Rezoning Transportation Analysis

Petition Number: 2021-152

From: Brandon Brezeale, PE

Date	Description
11-19-21	First Review (TM)

Apprvd:	
Date:	5/27/2021
Chkd:	SM
Drwn:	SK
Scale:	1"=20'
Project No.:	2021-009
Sheet:	RZ-1

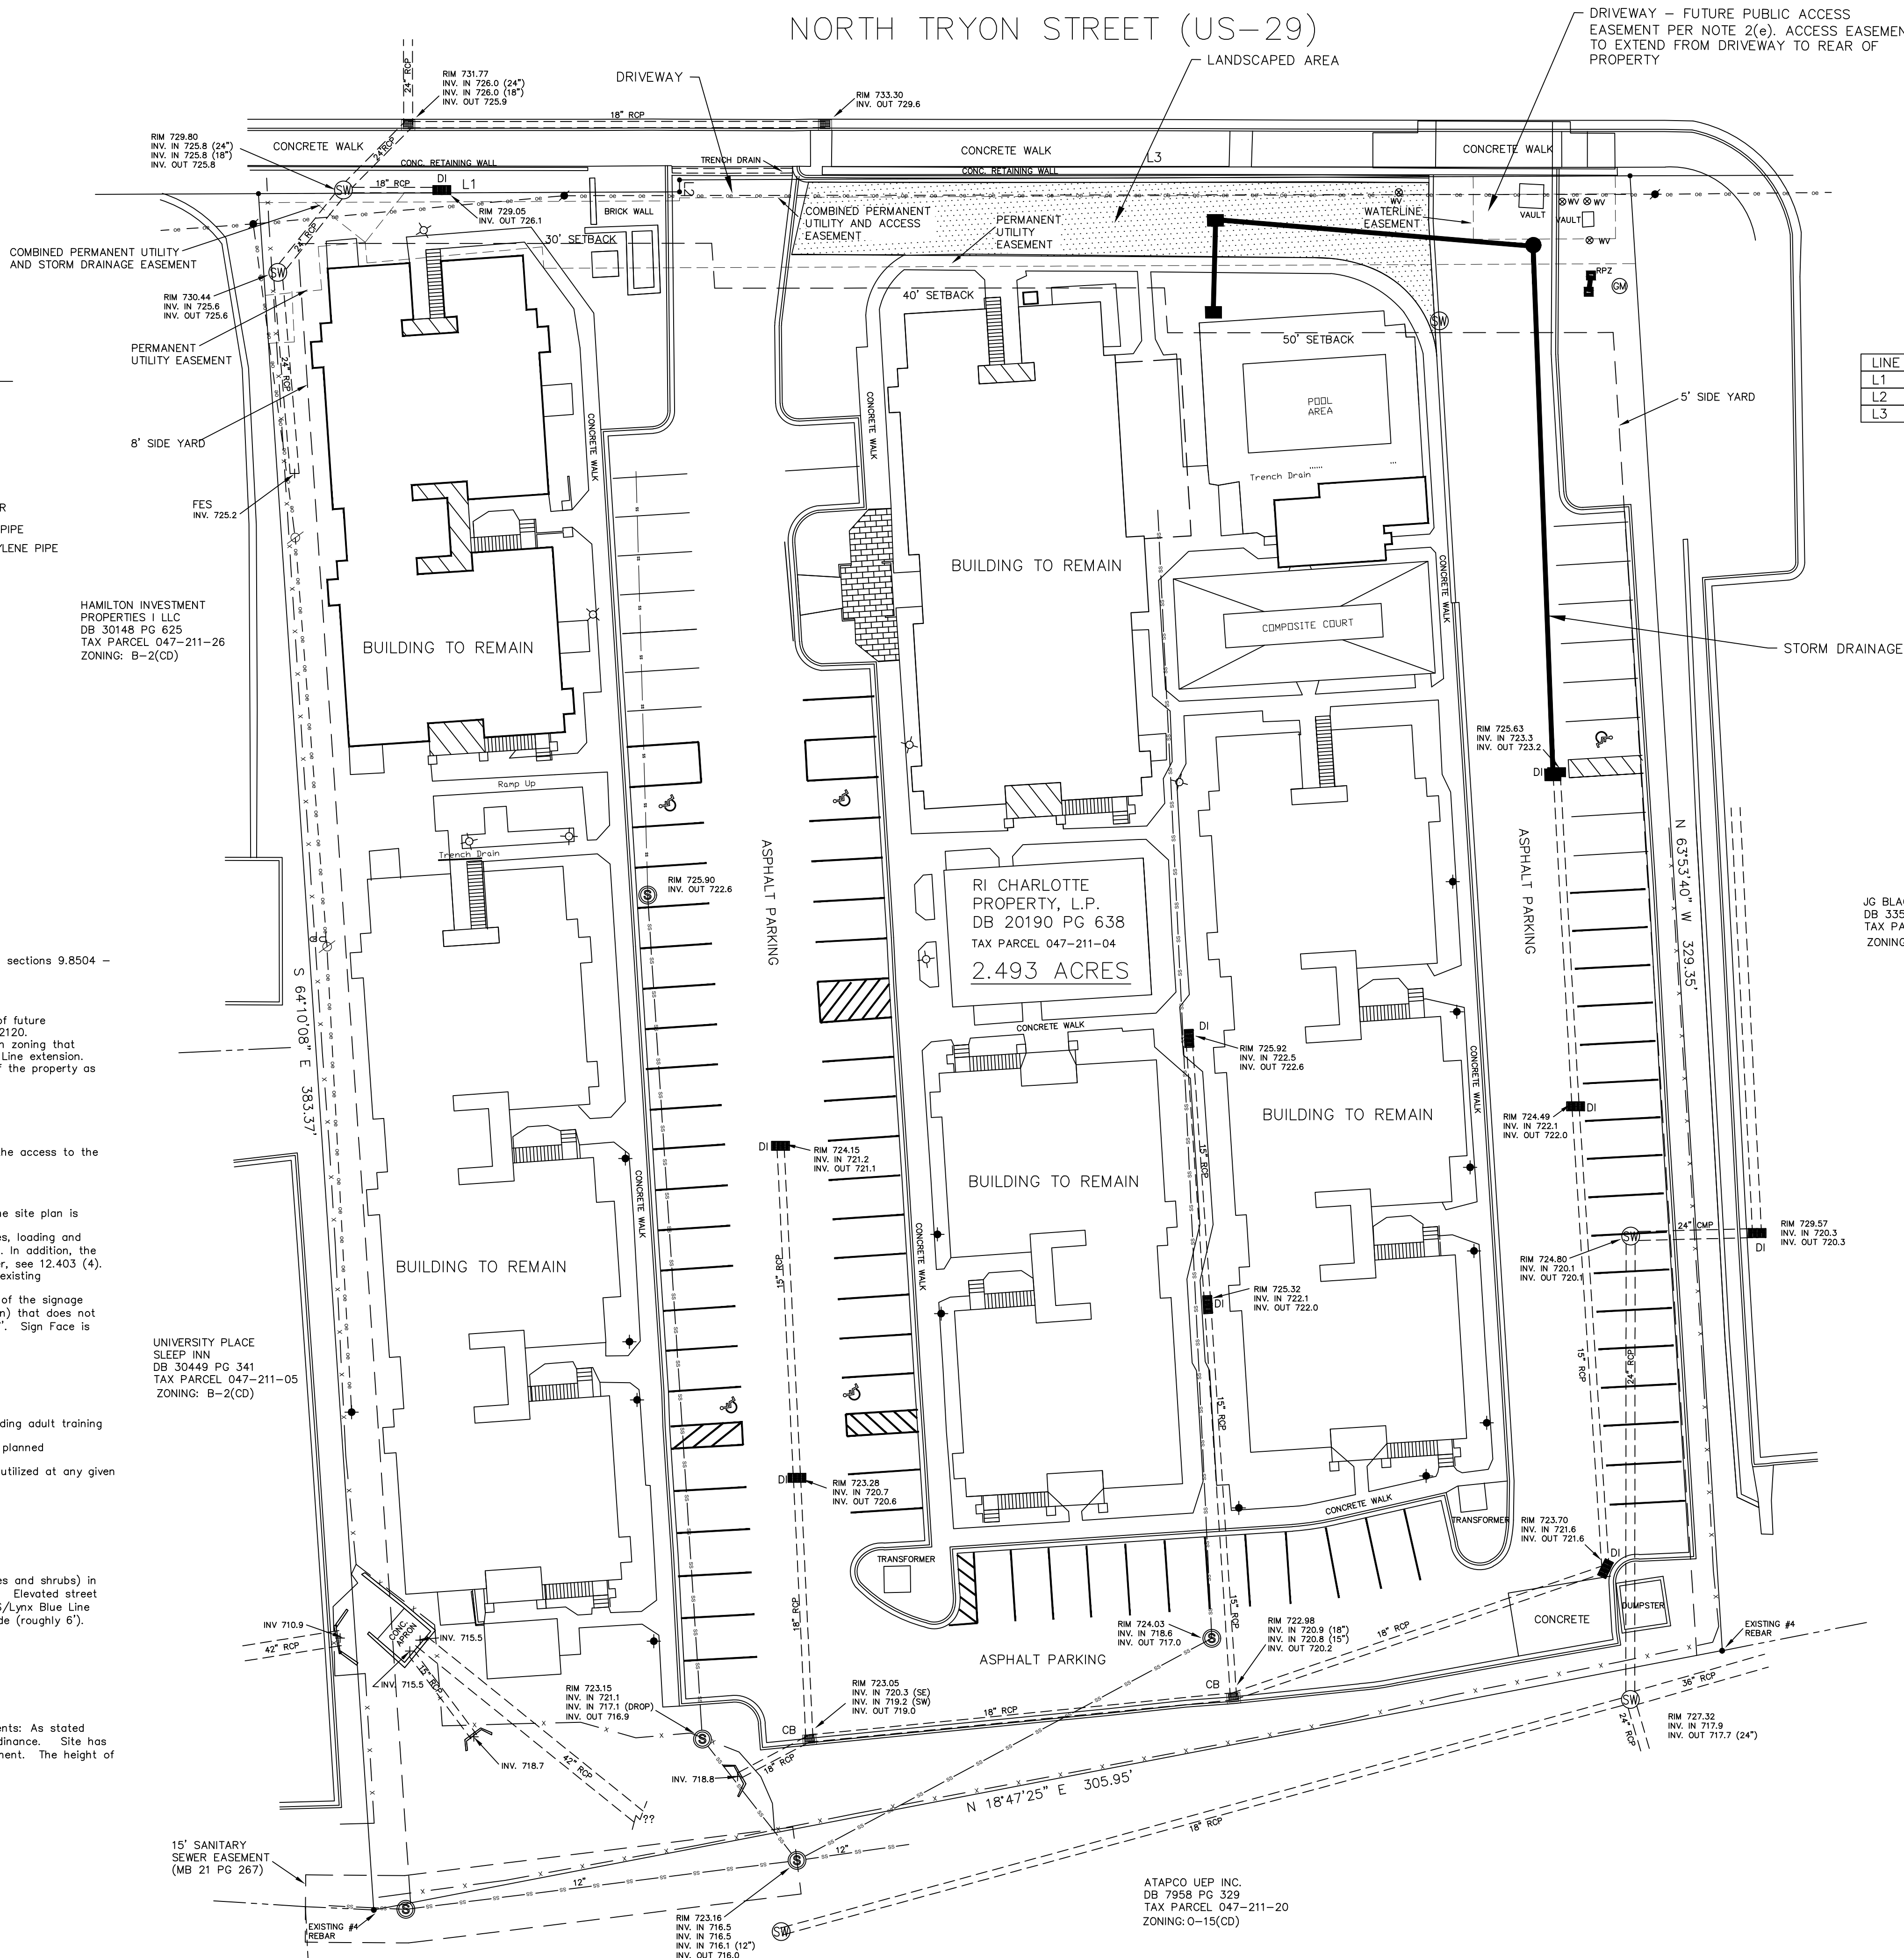
Site plan revisions are needed to meet ordinance requirements and the outstanding items including, but not limited to, labeling and dimension the right-of-way. Further details are listed below.

- Curb line:** The proposed zoning district has a setback measured from back of the existing or proposed future curb line.
 - Tryon Street:** The future location of curb and gutter is in its existing location.
- Traffic Study:**

A Traffic Impact Study (TIS) is not necessary for the complete review of this petition due to the site generating less than 2,500 daily trips. If during the permitting process the site generates more than 2,500 daily trips, then a traffic study will be required.
- Revise site plan by dimensioning the right-of-way from the existing centerline of Tryon Street.
- Add conditional note "All public roadway improvements will be subject to the standards and criteria of CDOT and NCDOT, as applicable, to the roadway improvements within their respective road system authority. It is understood that such improvements may be undertaken by the Petitioner on its own or in conjunction with other development or roadway projects taking place within the broad north eastern Mecklenburg area, by way of a private/public partnership effort or other public sector project support."
